SCOPING OPINION:

Proposed Morecambe Offshore Wind Farm

Case Reference: EN010121

02 August 2022

Title:
Study Area for Marine Sediment and Water Quality

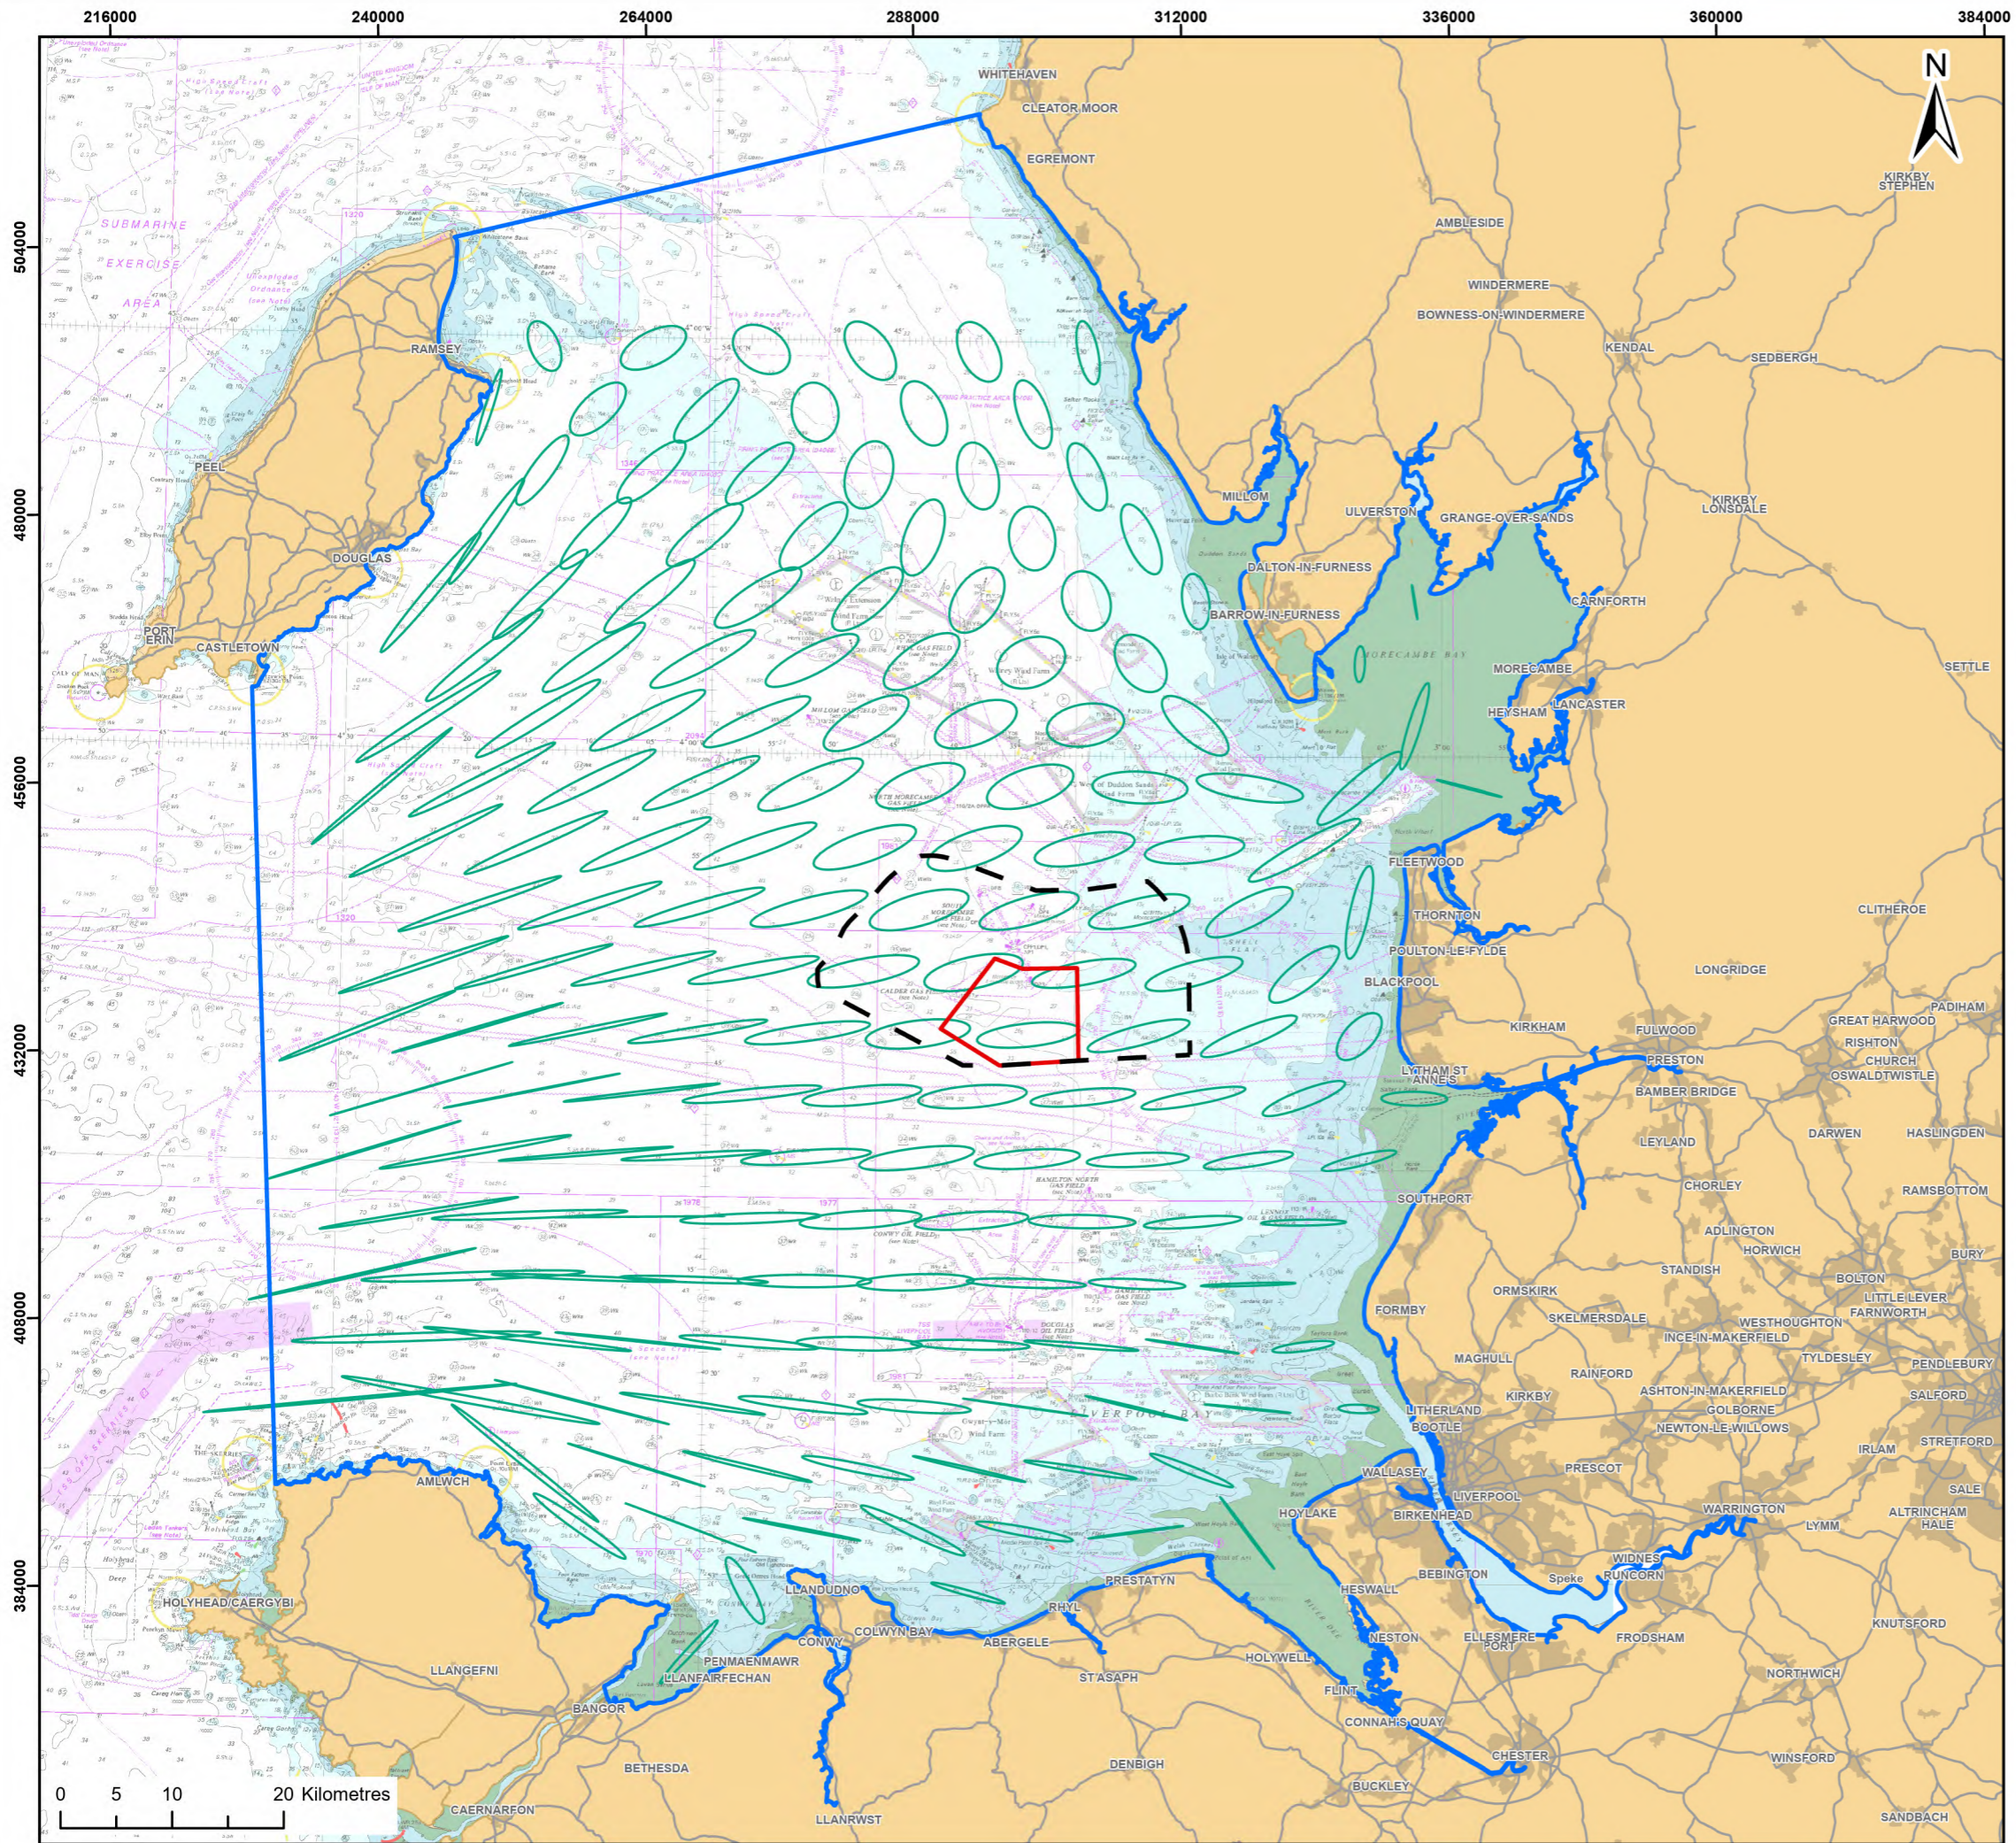
ID	Ref	Description	Inspectorate's comments
3.2.3	Paragraph 212 and Figure 8.1	Study area	<p>The study area is defined as the 'Morecambe Offshore Windfarm Site' as shown on Figure 8.1. However the scoping report states that the study area also includes areas beyond the windfarm site and across the wider regional seabed and coastline. This is not shown on Figure 8.1.</p> <p>The ES should include a figure clearly showing the boundary of the study area and provide a justification for the final extent.</p>
